Planning Application No: 3/2026/0274

Proposal: Proposed change of use and conversion of the existing detached garage into a single residential dwelling with parking.

Location: Ridings Cottage Whalley Old Road Billington BB7 9JF

Drawing Title  
Site Plan

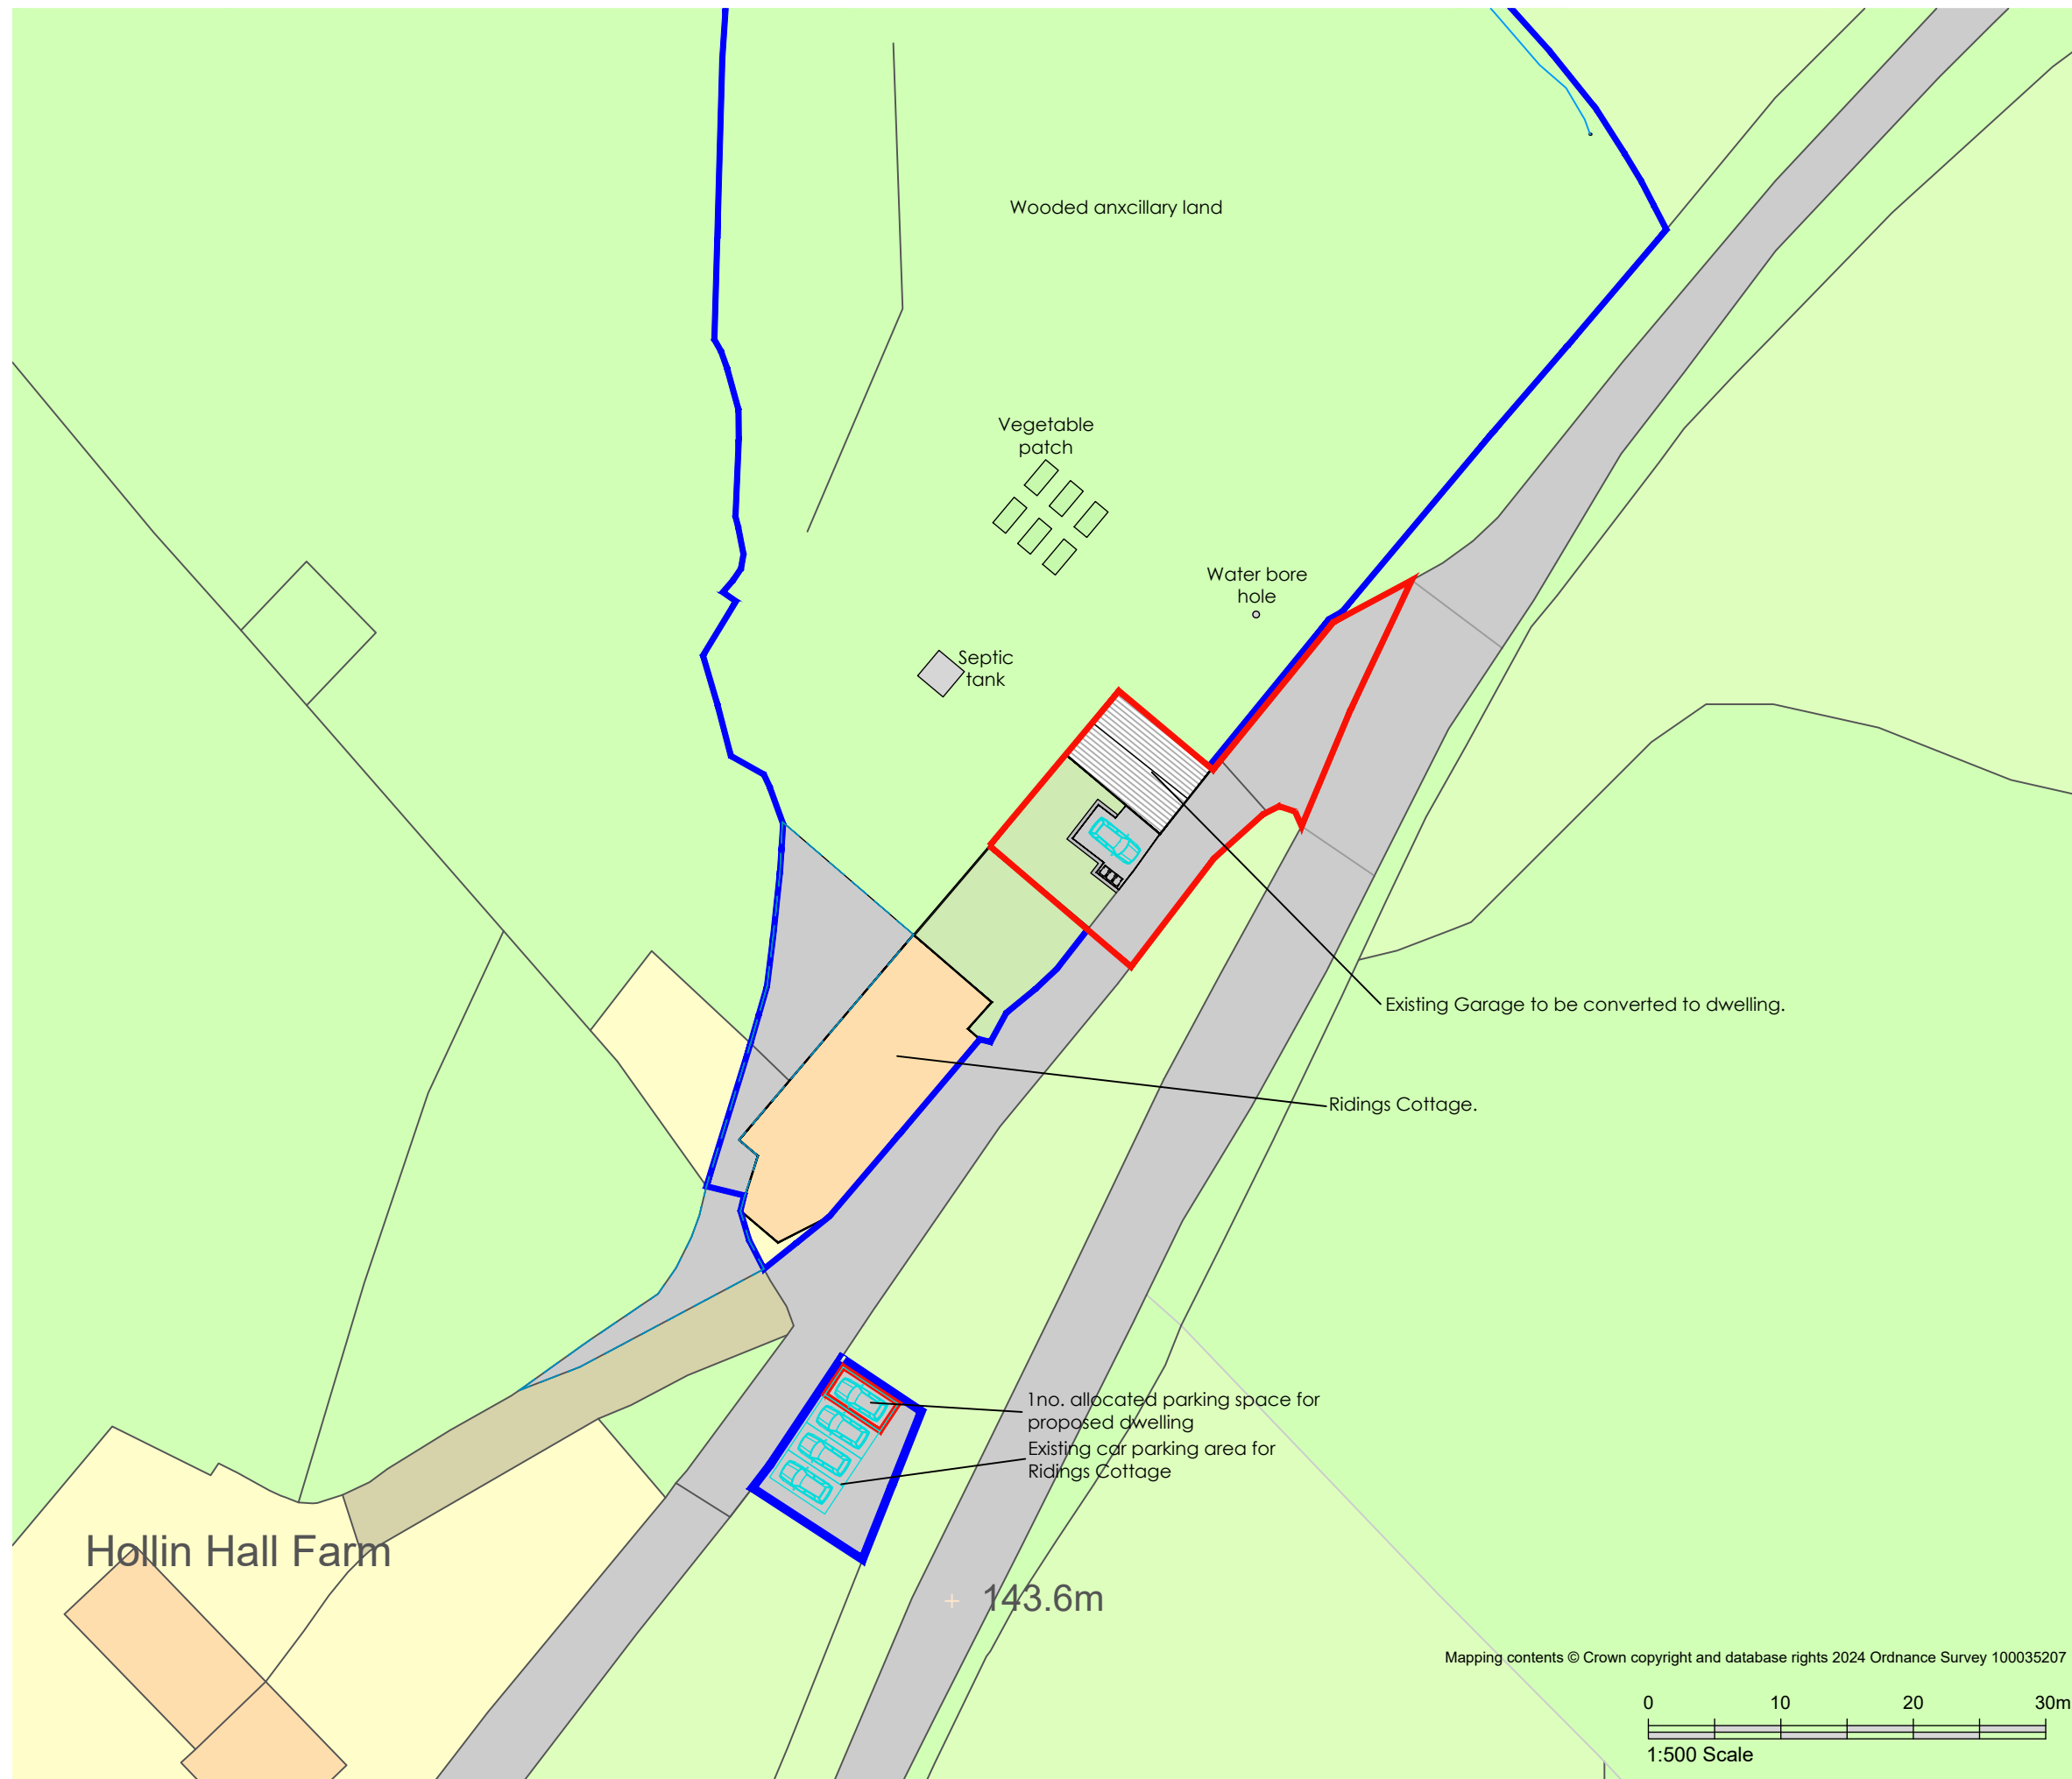
The private access track is currently in poor condition, to prevent loose stones from being dragged onto the highway, creating a hazard, the LHA will ask that the access junction be hard-paved for 5m behind the carriageway edge.

The LHA are aware that the site will have a new vehicle access located off a private access track, which also serves 4 other dwellings and a Public Right of Way, FP0306026. As such the access to the parking areas will need to be provided with 45° visibility splays between the boundary and points on either side of the drive measured 3m back from the nearside edge of the footway so that vehicles can observe pedestrians and any other vehicles along the private track before exiting the parking area.

The parking area situated next to the dwelling may need to be moved slightly in a south west direction to achieve a 45° visibility splays due to the proximity of the dwelling.

The LHA will request that access improvements take place to improve visibility to the south, as such any low lying vegetation that falls within the first 2m of the verge from the carriageway edge for 3m above land level will need be removed or reduced to 0.9m above the carriageway level. This will ensure that vegetation does not obstruct drivers' line of sight, particularly during the summer months.

The LHA are aware that 3 car parking spaces will be retained for the existing dwelling, Ridings Cottage, along with one additional space dedicated to the new dwelling. One additional space will also be provided in a new location next to the dwelling, given that this space will be bound by walls, the LHA would expect that the space be at least 3m wide, this is to allow a vehicle to park (2.4m) and provide additional room (0.6m) to allow the doors to open without being obstructed by the walls.

- Prior to first occupation, that part of the access, which forms the junction with Whalley Old Road, extending from the highway boundary, for a minimum distance of 5m back shall be appropriately paved in tarmacadam, concrete, block pavements, or other hard material to be approved by the Local Planning Authority. Reason: To prevent loose surface material from being carried on to the public highway thus causing a potential source of danger to road users.

- Prior to first occupation, the existing vegetation to the South of the access shall be reduced to 0.9m above the carriageway level or removed for the first 2m along the boundary with the public highway and maintained as such thereafter to protect visibility to and from the site. Reason: In the interest of highway safety.

- The development hereby permitted shall not be occupied or brought into use until the car parking and turning areas shown on the approved plan have been provided in full and are available for use. The car parking and turning areas shall thereafter be kept available for the parking and manoeuvring of vehicles at all times. Reason: To ensure the provision of adequate car parking on site and in the interests of highway safety.
